Re: Powell Amenity Center and Pool

This department has reviewed the revised plans you submitted for the Powell swimming pool to be constructed at 212 Perseus St., Lillington. This plan review was conducted in accordance with the current North Carolina Rules Governing Public Swimming Pools (15A NCAC 18A .2500).

The plans are not approved as drawn. The following items need to be addressed:

POOL LAYOUT PLAN
 1/8" = 1'-0"

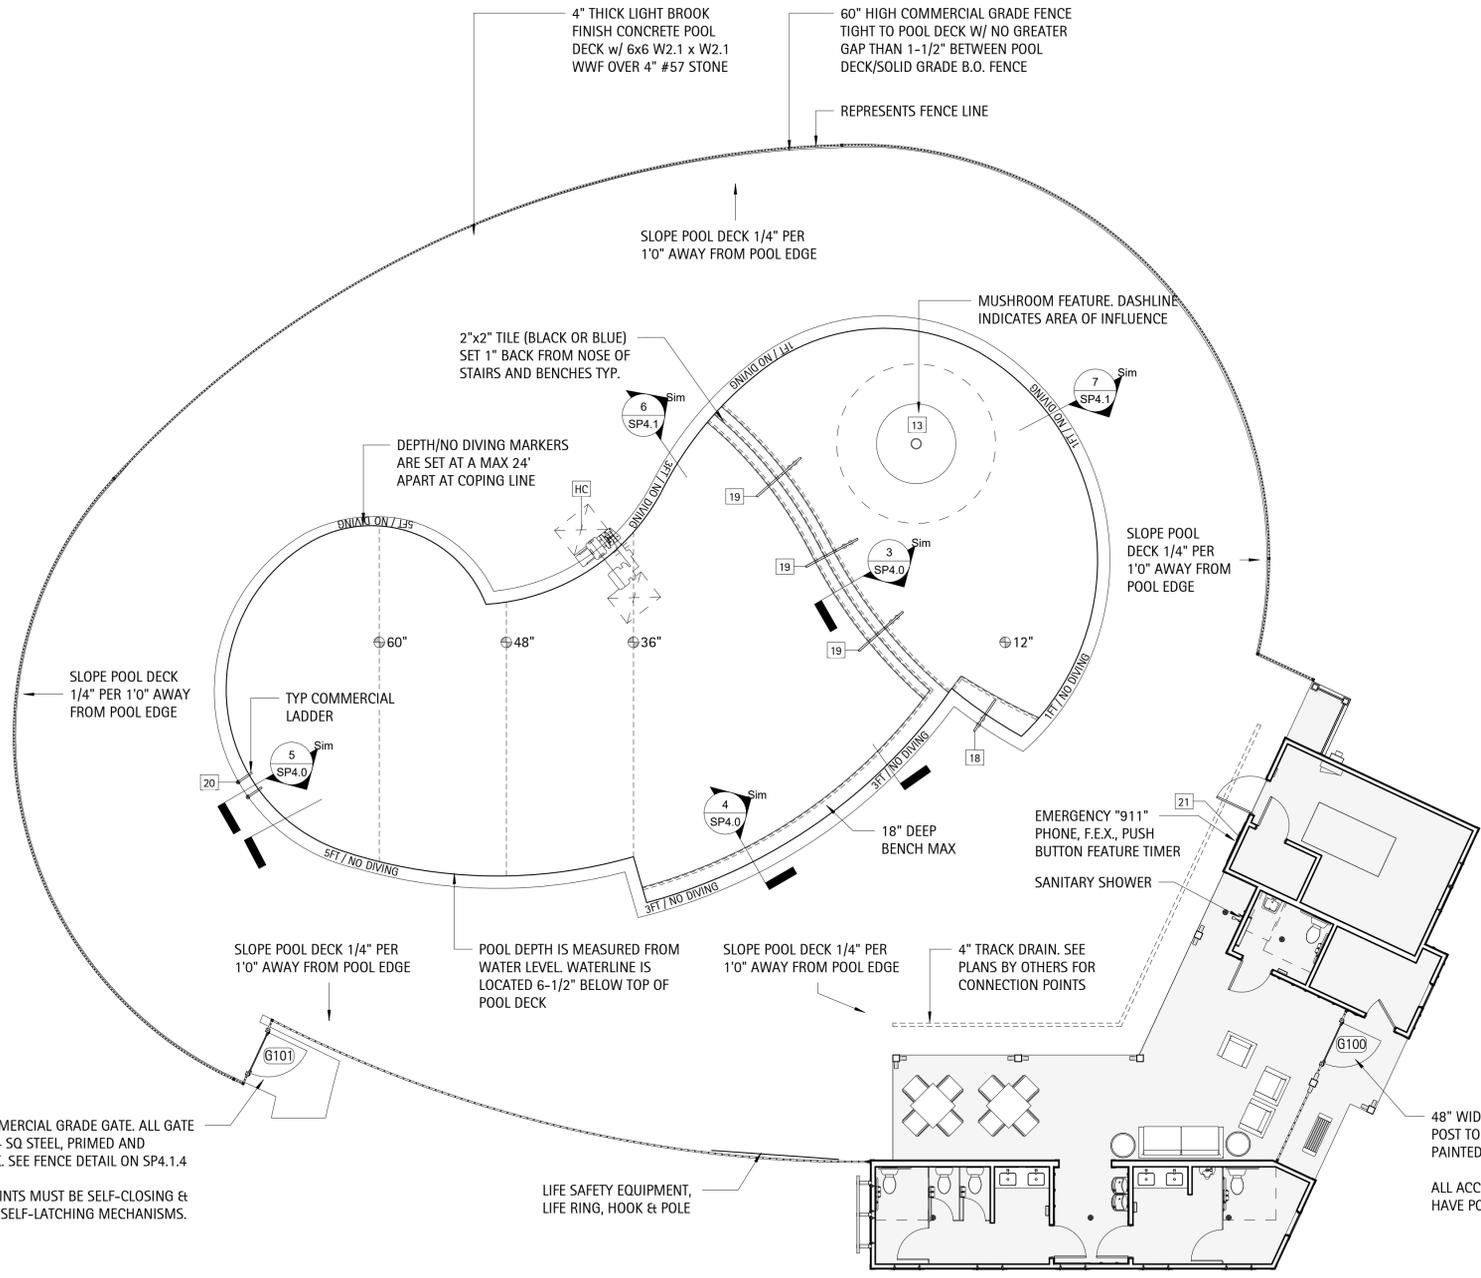
- The main drain line as drawn is specified as a 2" line. The main drain line shall be a 4" minimum line.
- The Circulation and Feature SOFAs have not been revised on the plans to show items indicated in a letter dated August 27. The Circulation SOFA cannot be approved as drawn.
